**Consultation Response from KC,
Lead Local Flood Authority**
2020/91468 Former North Bierley Waste Water Treatment Works, Oakenshaw, BD12 7ET
Discharge of conditions 5 (Phasing Plan), 11 (Sewer Overflow), 13 (Foul Water Drainage), 14 (Discharge of Surface Water), 23 (Flood Risk) and 24 (Disposal of Surface Water) on previous permission 2016/92298 for outline application for re-development of former waste water treatment works following demolition of existing structures to provide employment uses (use classes B1(c), B2 and B8)
**Date Responded: 23 June
2020**
**Responding Officer: Alex
Fraser**
Responding Ref: 0
Kirklees LLFA Summary

Kirklees LLFA **OBJECT** to the discharge of conditions 14, 23 and 24 due to lack of information within the documents uploaded.

Drig Title: BULK EARTHWORKS
LEVELS
PHASE 1

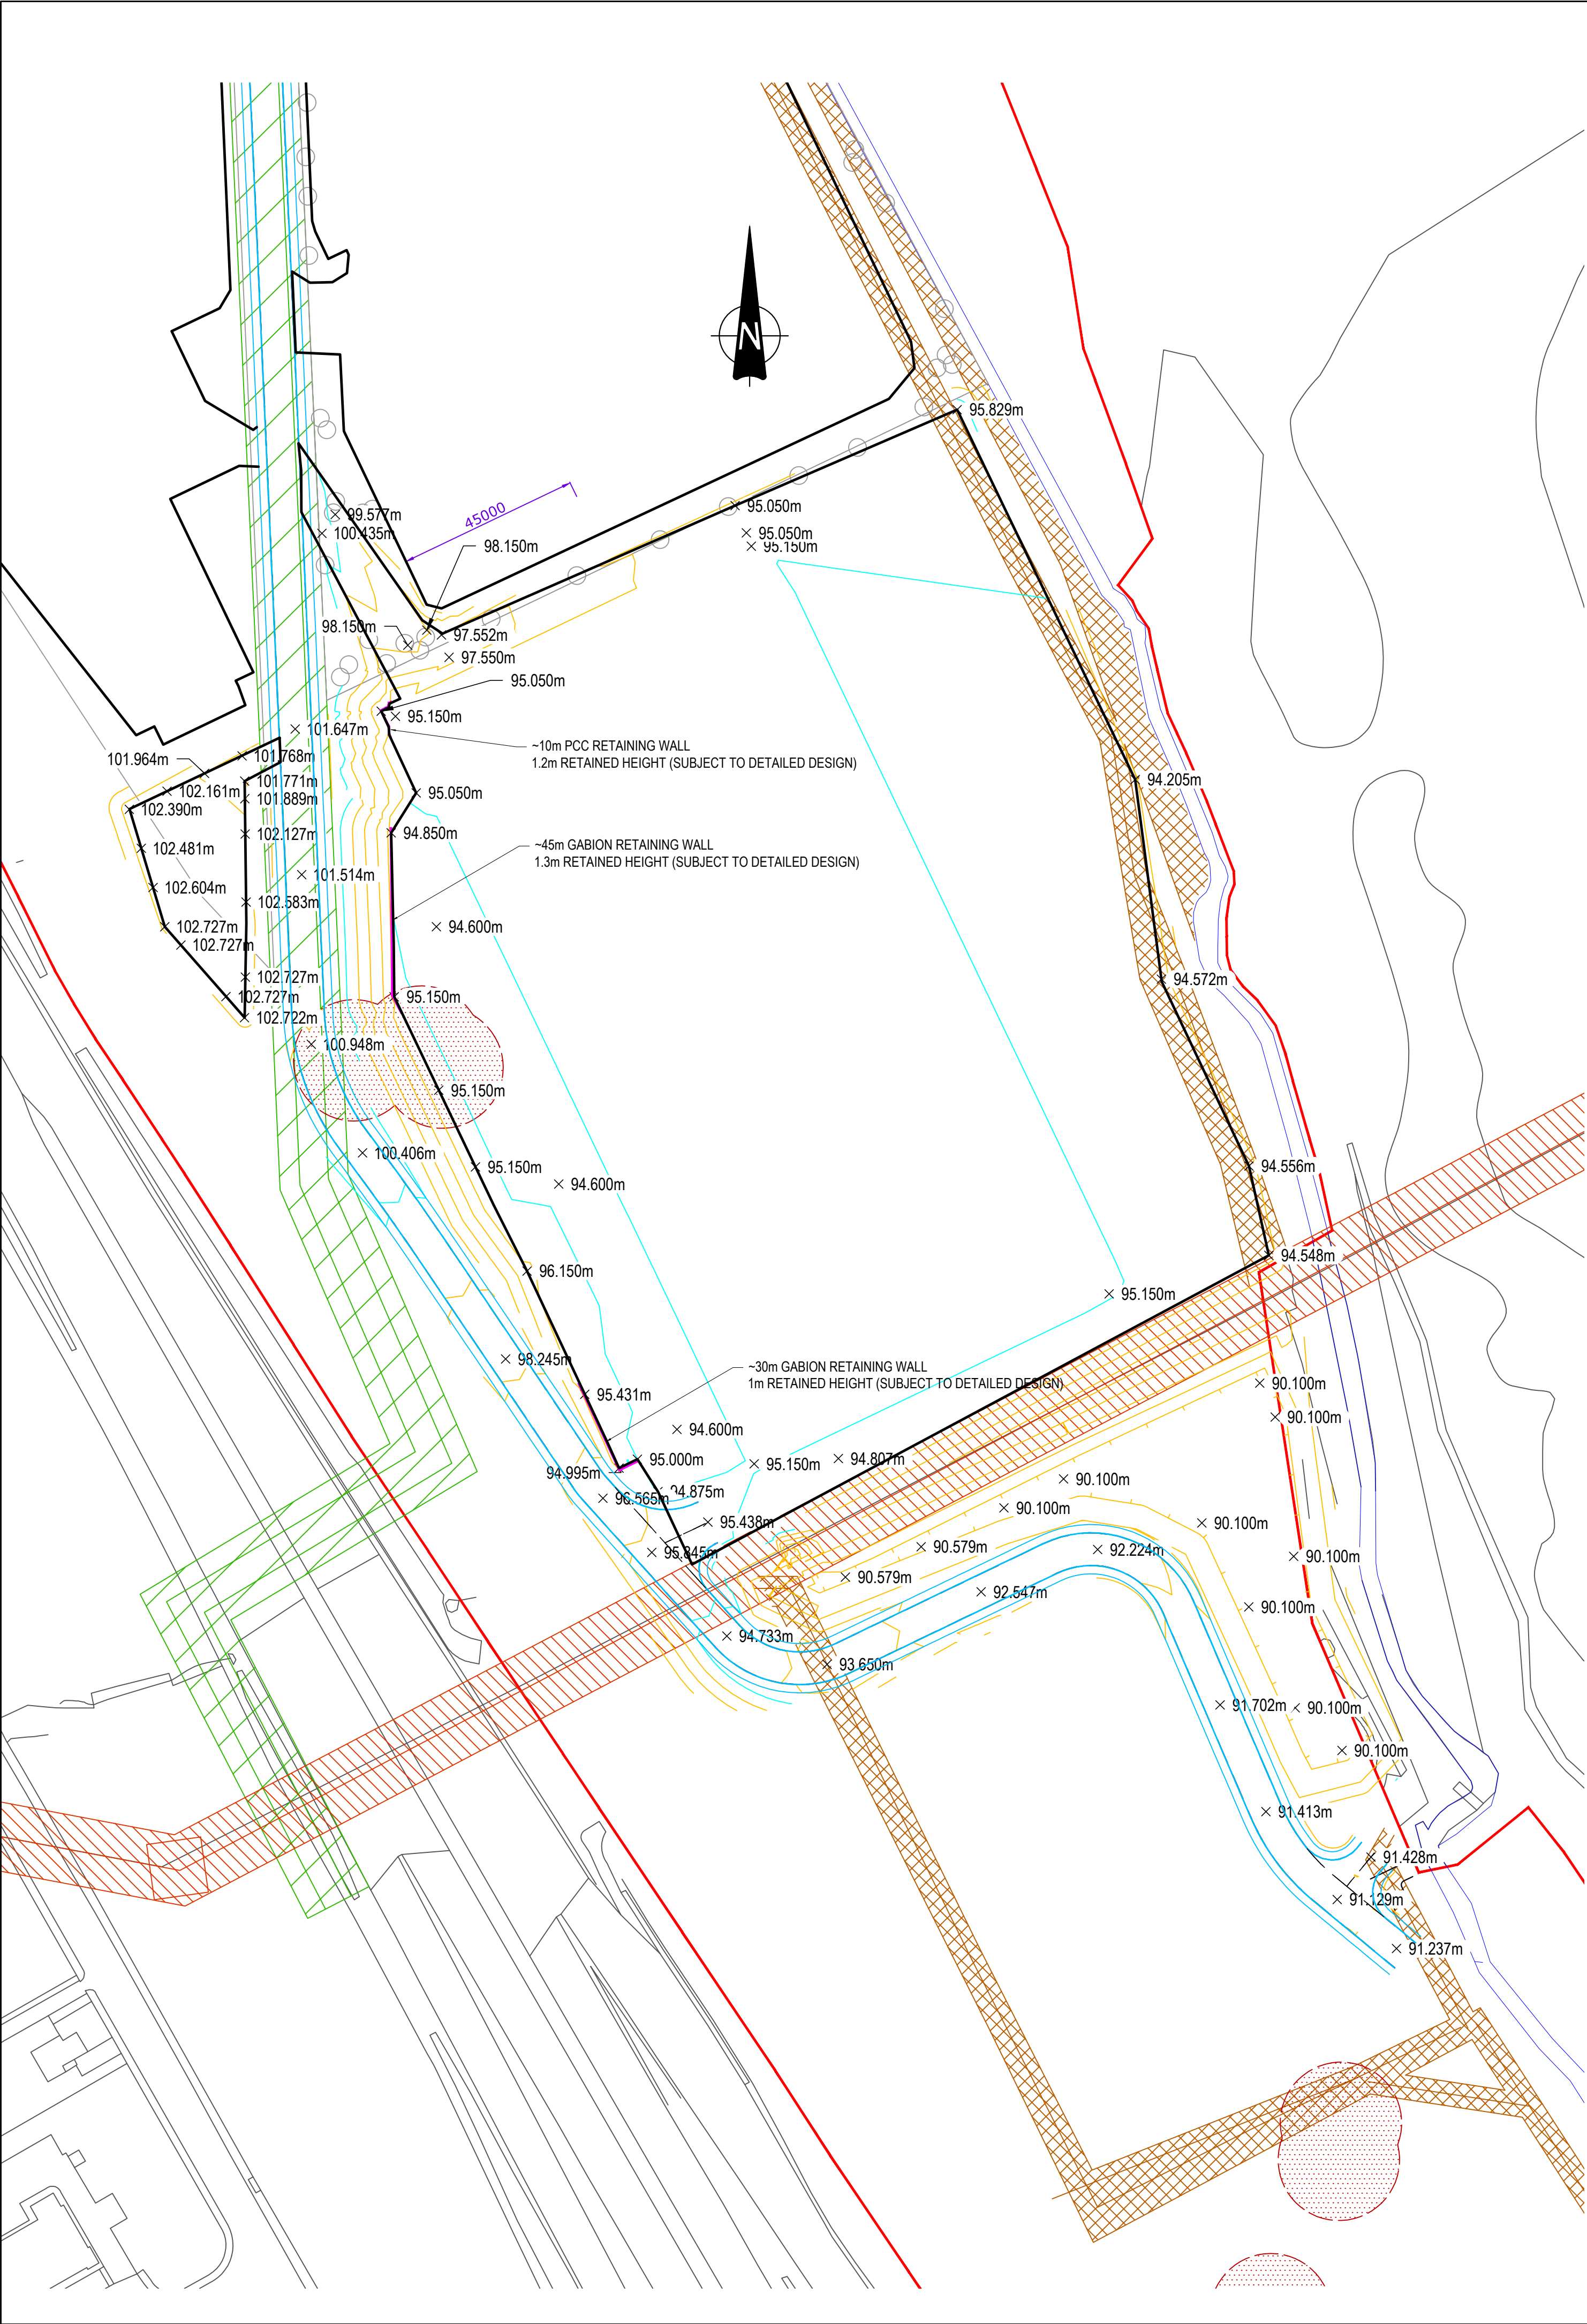
The applicant proposes to utilise attenuation basins but provides no information on their form, design or layout. This is insufficient for Kirklees LLFA to assess the proposals; all parts of the drainage network must be shown on plans. Kirklees LLFA also request that an overarching site plan showing all drainage is provided so it is possible to understand drainage routes across the site.

S104 DRAINAGE
LONGSECTIONS SHEET 1

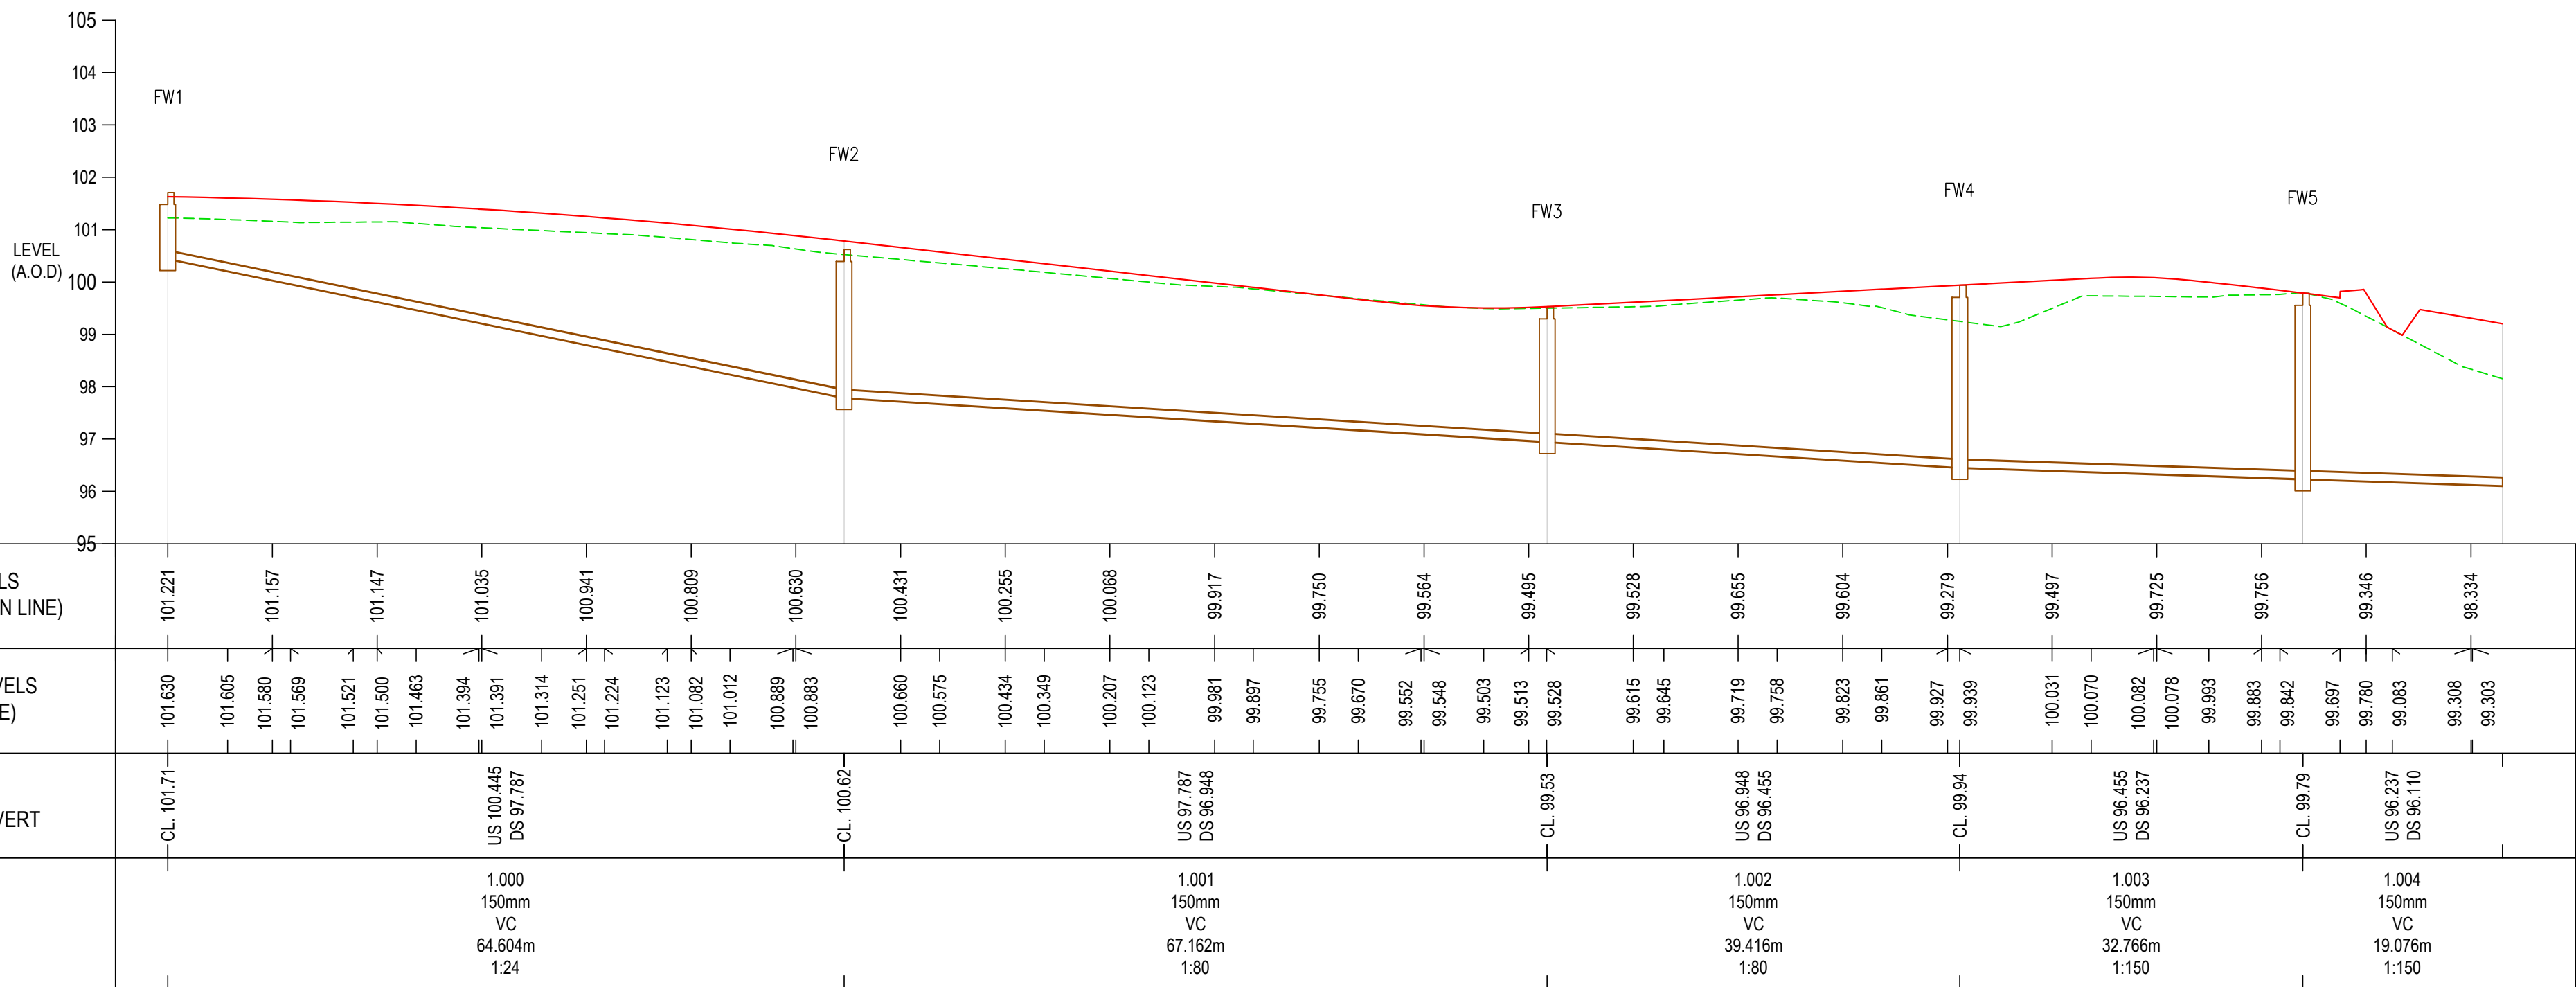
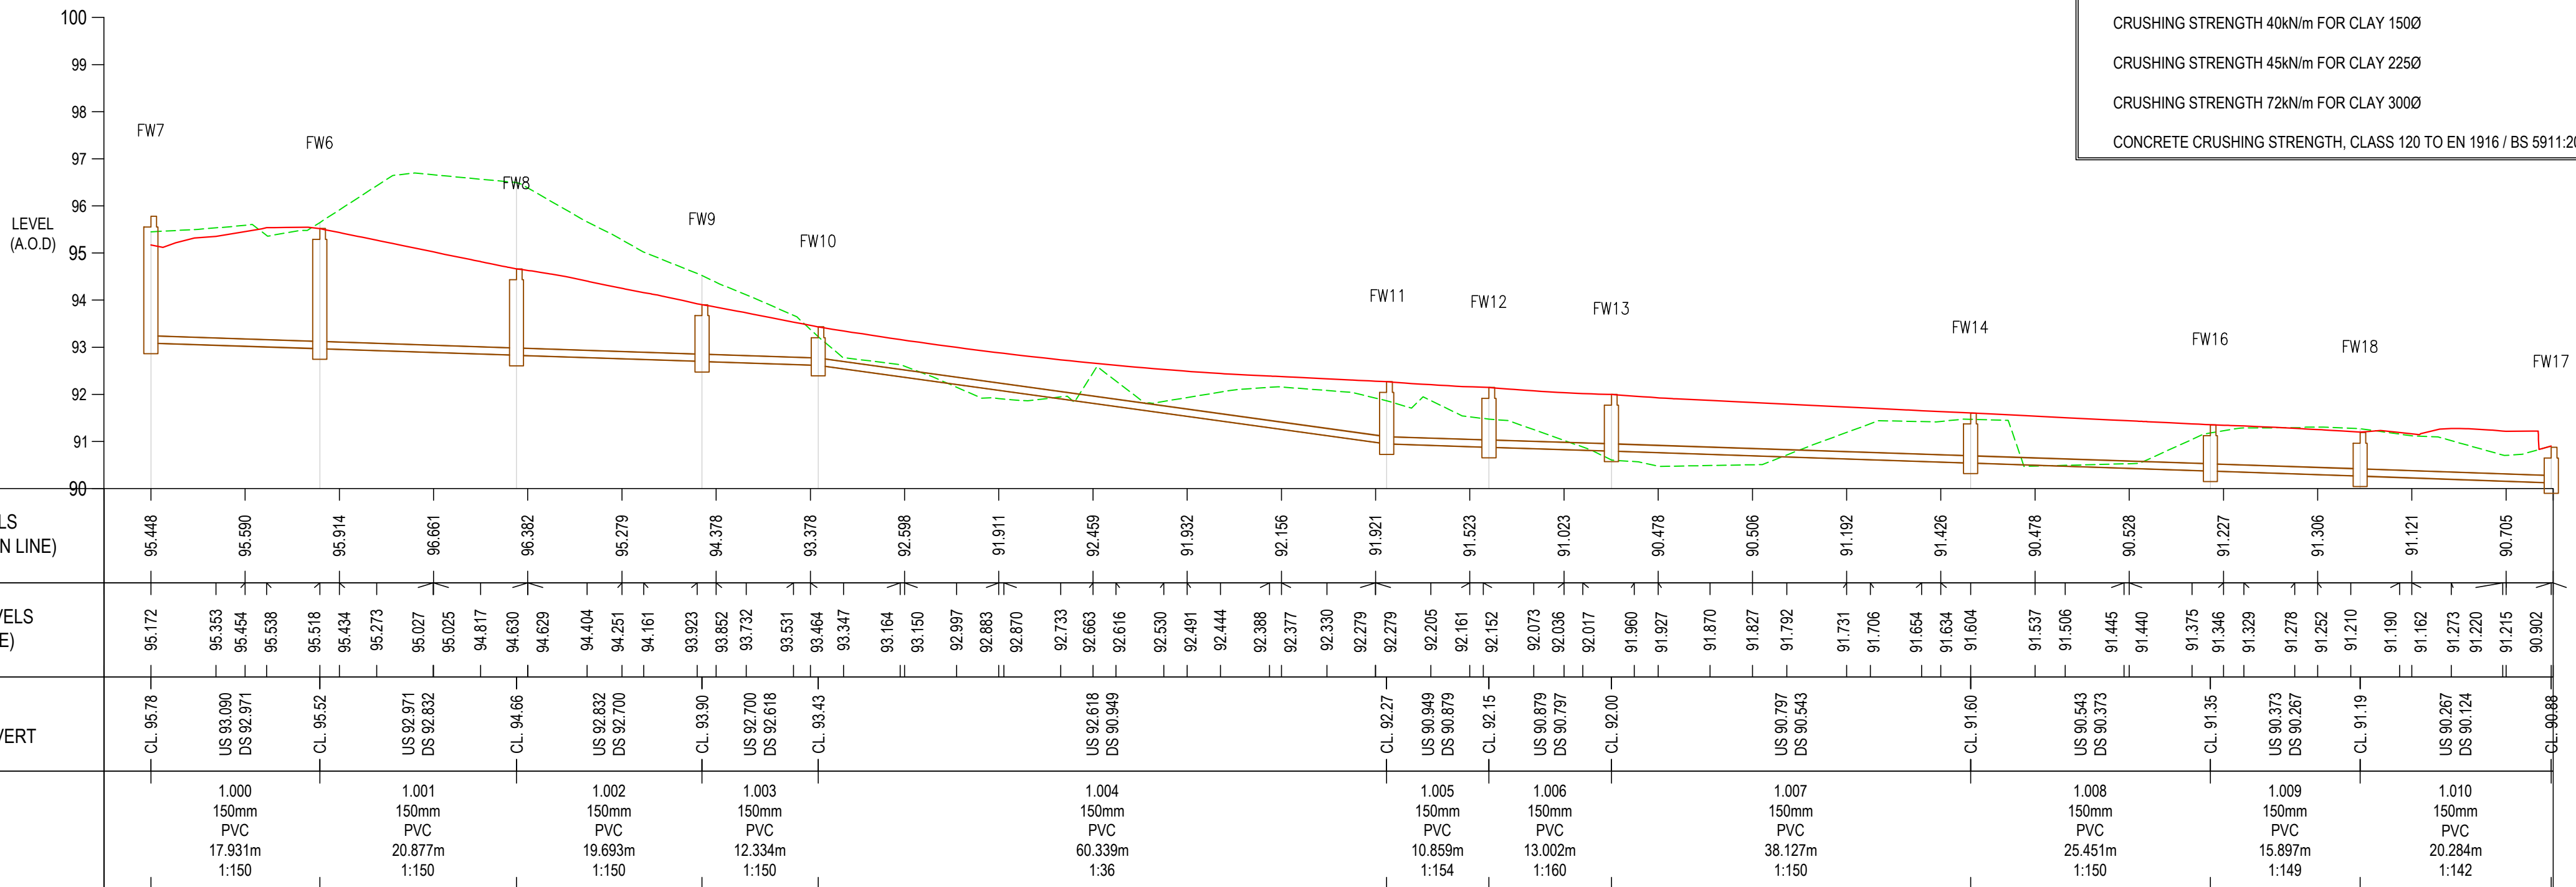
The applicant has solely submitted a series of Causeway Flow calculations for the site, coupled with plans showing the site's proposed drainage layout. The applicant's drainage consultant uses an M5-60 value of 17 in the production of the drainage design. Kirklees LLFA request the applicant review this, within the Kirklees District there is no location with an M5-60 lower than 18, as can be seen in the below extract from Flood Studies Report taken from a Kirklees LLFA report assessing a similar M5-60 proposal for another site (**annotations are not for this site**). There have been updates since the original FSR and software such as MicroDrainage have these maps incorporated so there is some interpretation differences but an M5-60 value of 17 has not been correctly provided anywhere else across the district.
